RE: Montessori of the Rio Grande Charter School (H12/ D008A)

I am submitting the revised Grading plan for the school addition project. Your review comments of February 2 have been addressed as follows:

The proposed development will have a minor (<5%) impact on runoff which increases from 10.5 to 11.0 cfs. Onsite storm water detention with the proposed 5,700-gallon cistern and surface storage will mitigate this increase and minimize any impact on downstream drainage facilities.

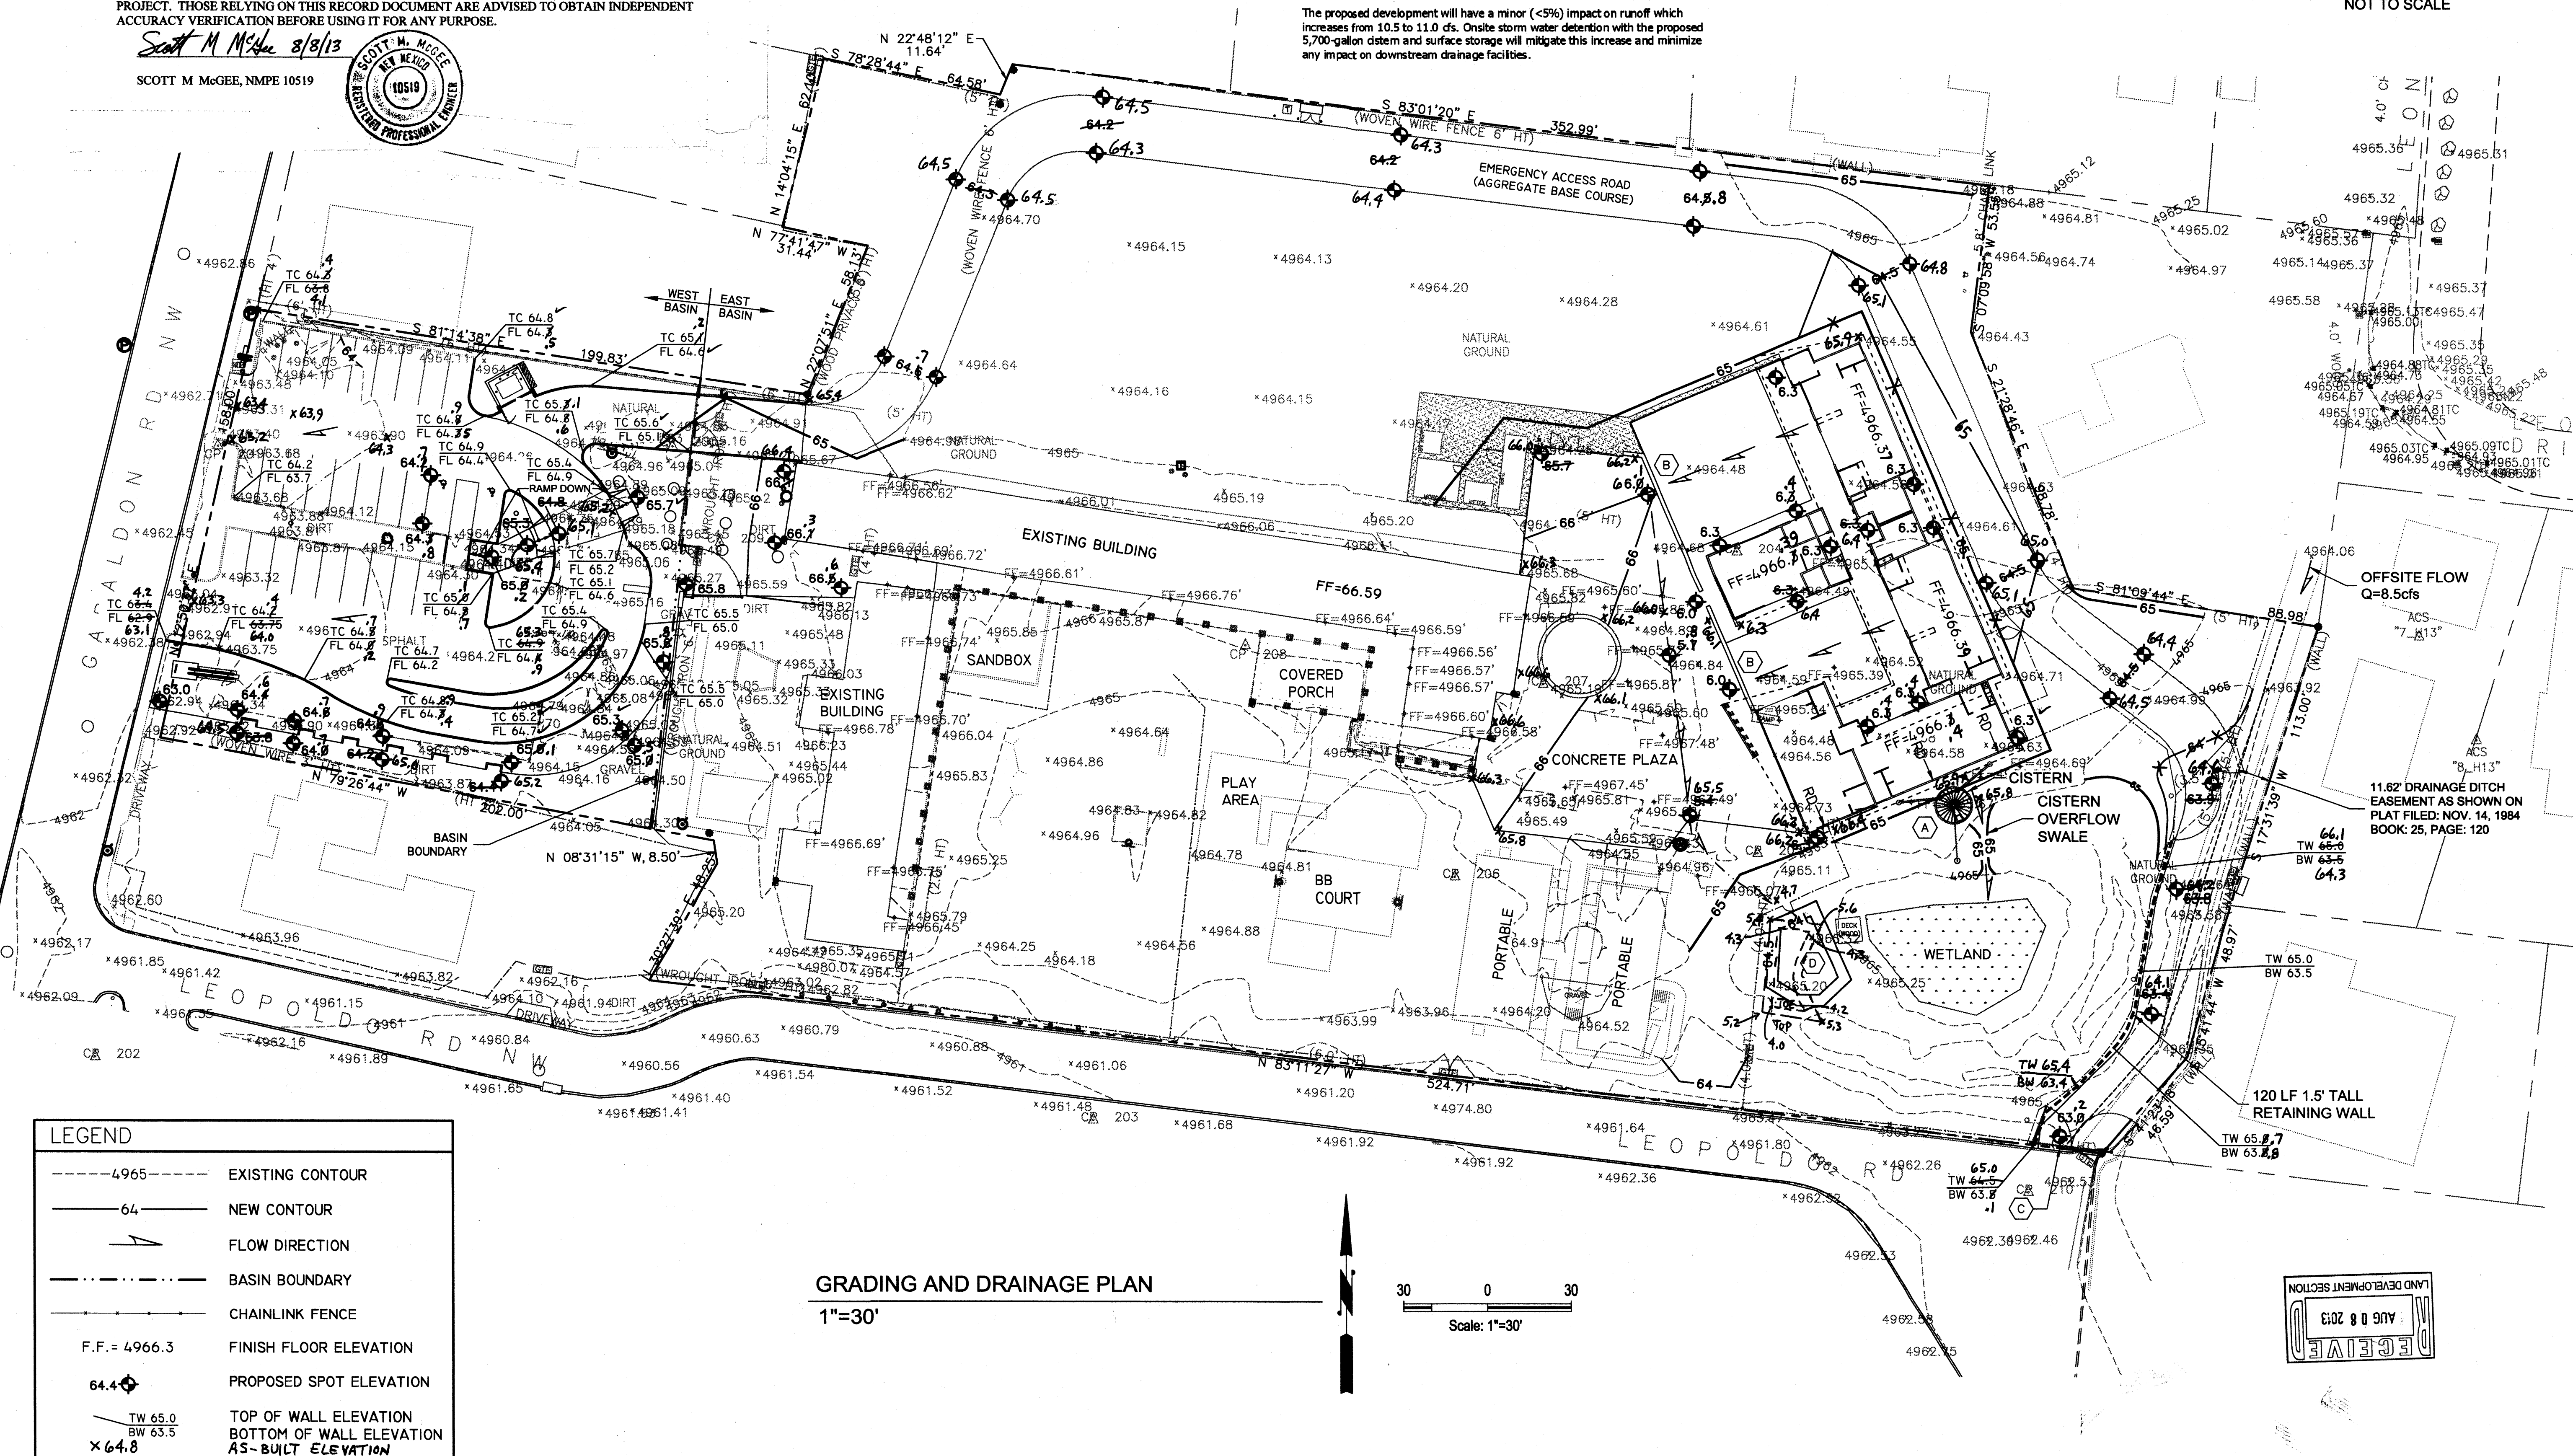
- < The Vicinity Map has been revised.
- < The site is not being replatted or rezoned. The State Board of Education owns the land and is not subject to City zoning requirements.

- < Additional spot elevations have been added.
- < The emergency access road has proposed spot elevations.
- < There isn't an irrigation ditch on the property—MRGCD approval isn't required.

- < Offsite flow enters the property from Leonora and flows along the east side of the site where it exits to Leopoldo Road. The drainage text now addresses this.

- < With respect to impervious area—the change to the west parking is minor.
- < Landscaped areas are existing in the west basin area which limits regrading.

- < The sidewalk south of the parking entry drains west. The landscaping in this area is existing.
- < The spot elevation has been revised.
- < A basin boundary line has been added to the plan.

- < Pond volumes have been calculated and are shown in brackets in the plan text.
